**Application for a non-material amendment following a grant of planning permission,  
Town and Country Planning Act 1990**

**Non-material amendment to previous approval (ref: 2023/90066) of variation of  
conditions 2 (plans) and 6 (highway layout) of previous permission 2019/91836 for  
erection of 34 dwellings**

**Land adjacent to Inkerman Court, Barnsley Road, Denby Dale, Huddersfield, HD8  
8XA**

**Application Number: 2023/92838**

SUB STATION - BARNESLEY ROAD, DENBY DALE

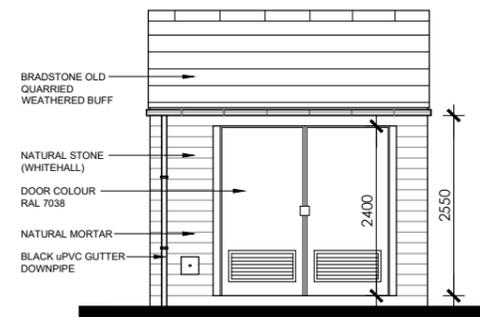
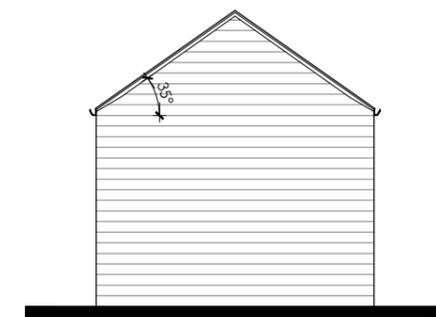
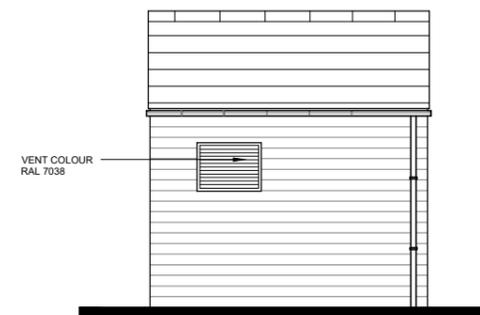
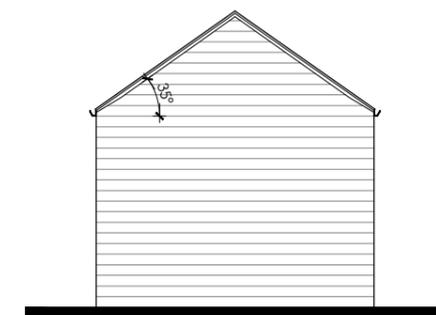
The council’s decision below is based on the electricity substation’s roof being of a simple hipped design (as shown in drawing 1903-SU-01 rev A), and not a hipped/pyramid design as shown in other drawings.
